**FINAL DRAINAGE REPORT
FOR
SADDLEHORN RANCH – FILING 5 EARLY GRADING**

**August 17, 2023
Project No. 25142.07**

**El Paso County PCD File No.:
EGP226**

SADDLEHORN RANCH - FILING 5 EXISTING CONDITIONS MAP

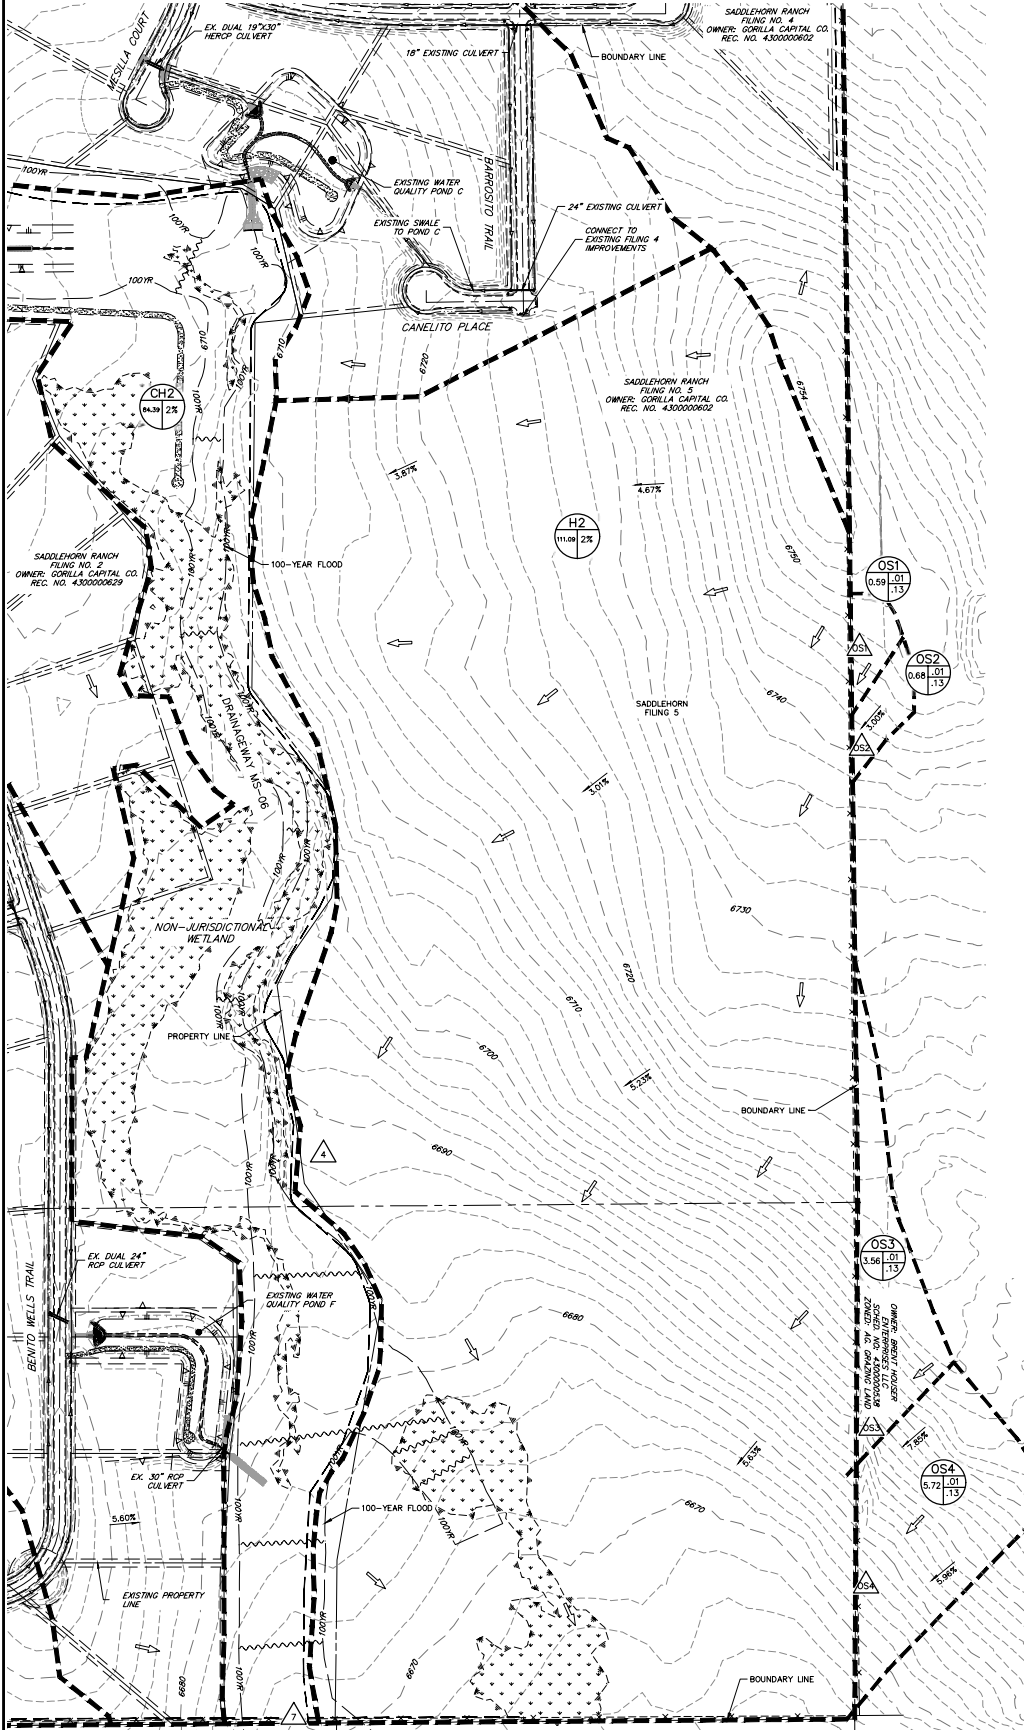
Sub-basin H2 is comprised of rolling rangeland and runoff flows southwest to Drainageway MS-06 as represented by Design Point 4 (Q₁₀₀=91.1 cfs). **Include 4 offsite basins, basin CH2 & design point 7 in discussion**

SADDLEHORN FILING 5 EARLY GRADING PROPOSED DRAINAGE MAP

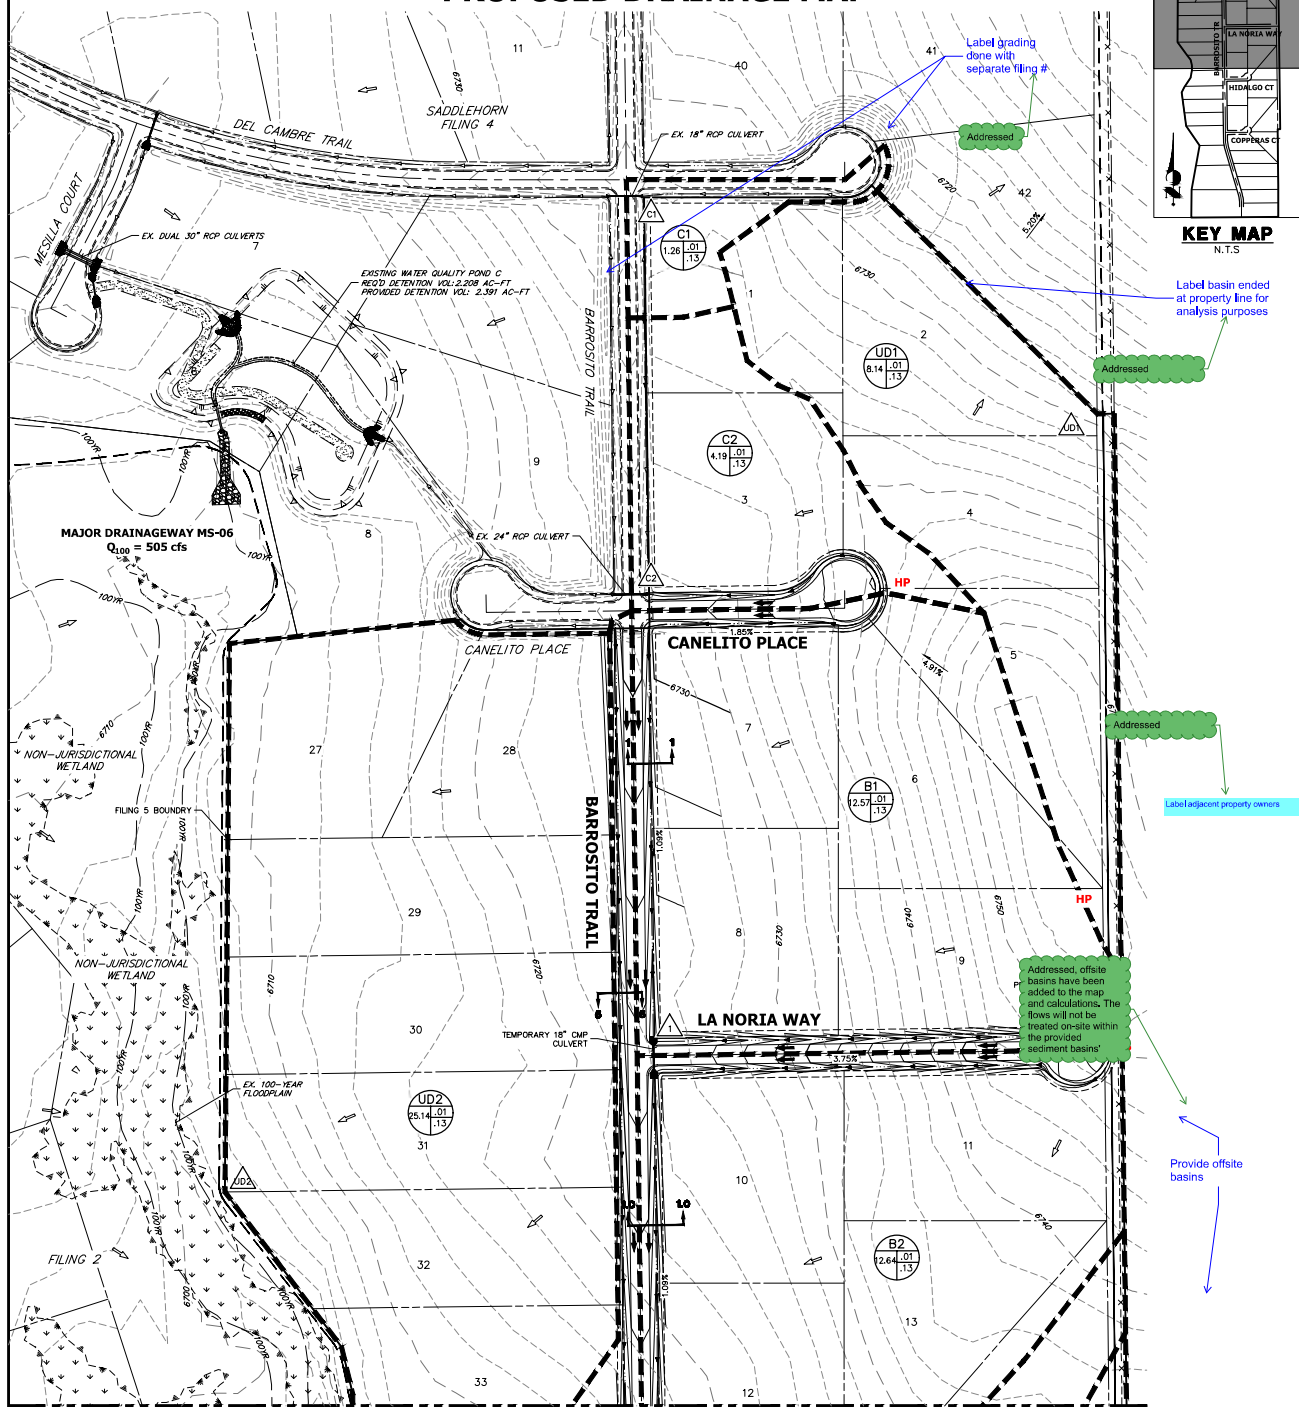
59.24 for Basins B1 to B5. Does this include OS1 & OS2? then include them in the discussion that OS1 & OS2 are also diverted to Sed Pond 1

Unresolved: Address how much acreage and flow is diverted and its effect on the drainageway
